From: Amanda Scholes on behalf of Planning.Responses
Sent: 20 June 2018 08:33
To: Planning Scanning
Subject: FW: The Coach House, Norton Lane AL/43/18/DOC

Further Drainage comments

SITE PLAN 1:200 @ A3

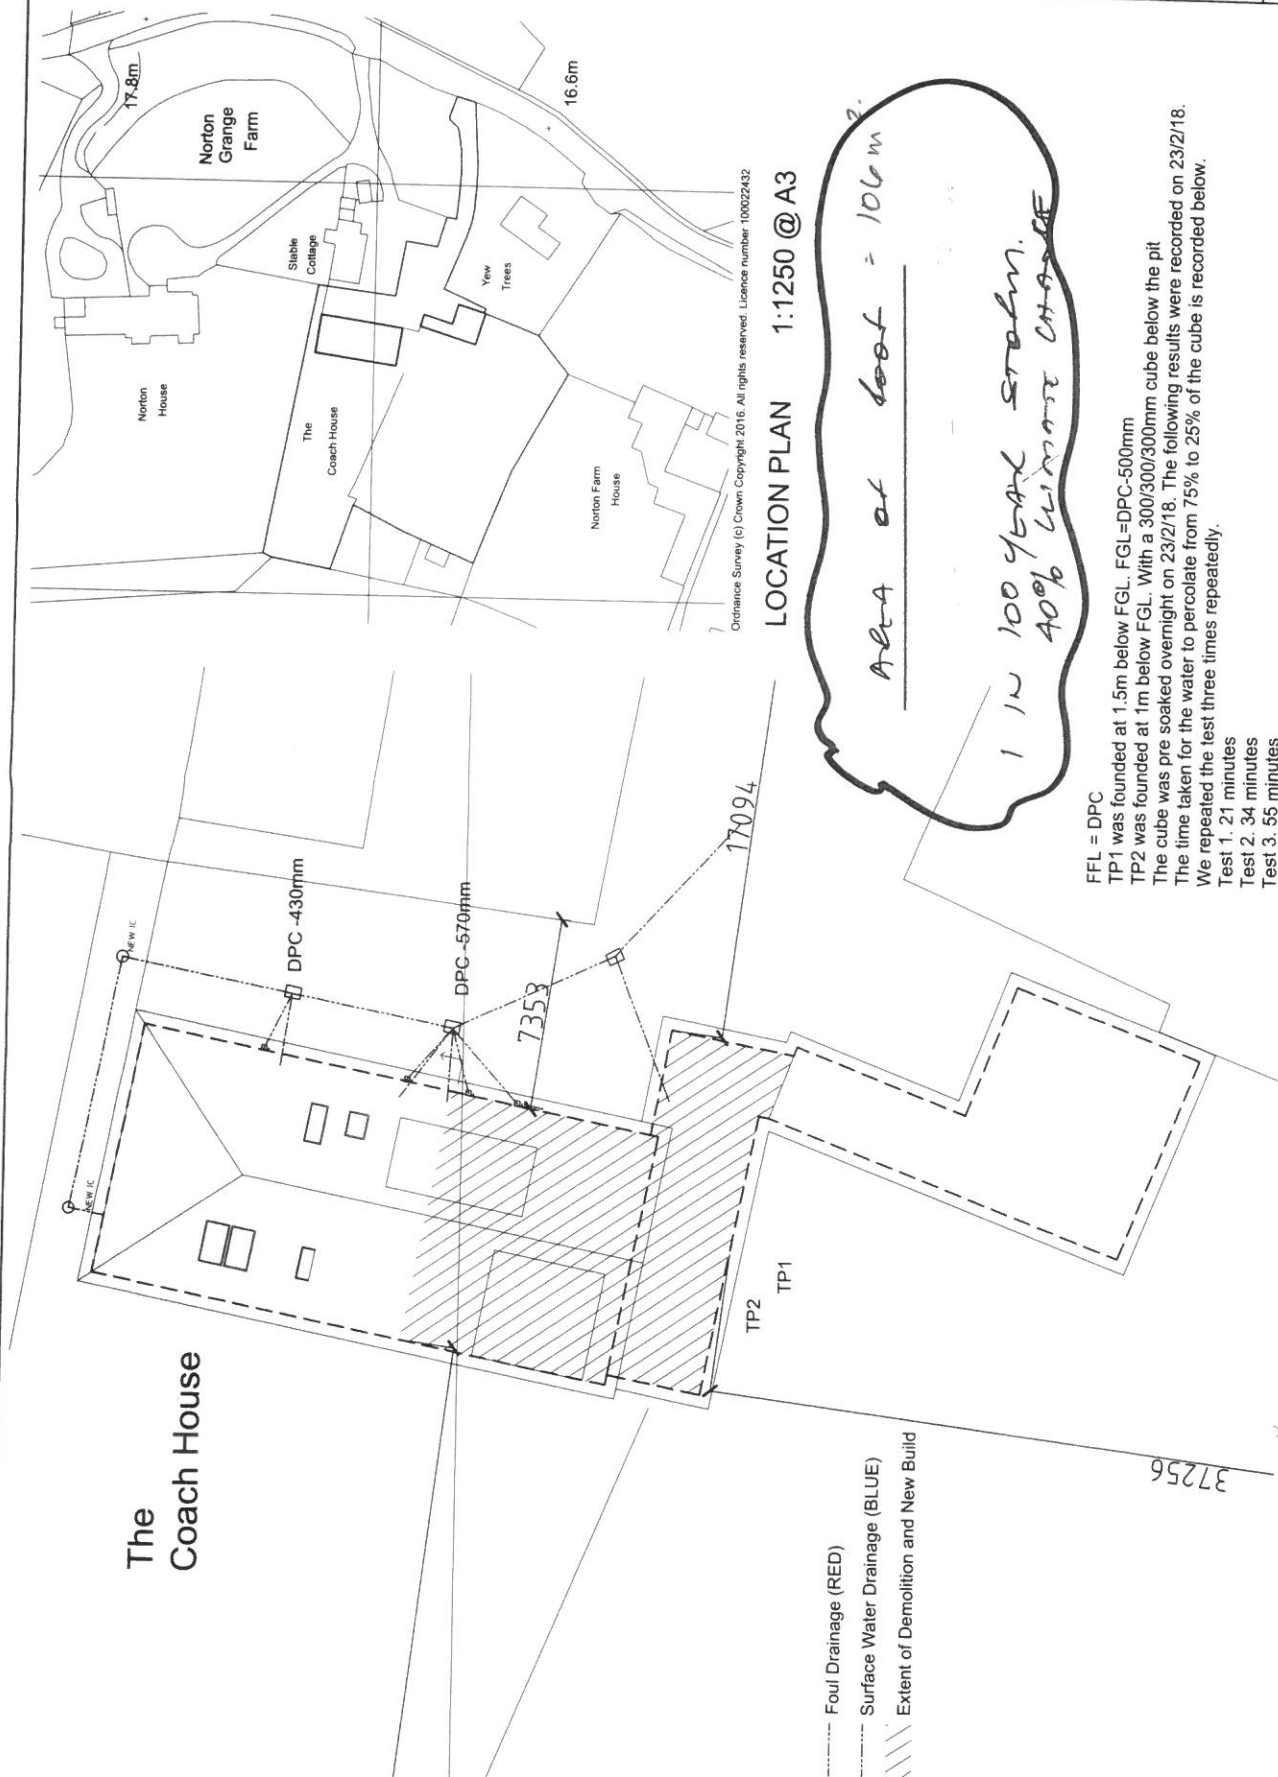
Based on the fact that the winter groundwater monitoring was limited I would like to ensure that the base of the soakaway is set no lower than 1.2m deep. And a factor of safety of at least 1.5 (preferably 2) applied to the calculations, in line with CIRIA R156/ CIRIA C609. Based on my calculations this will likely require a slight increase in the tank area from 3m by 3.5m to 3m by 4m.
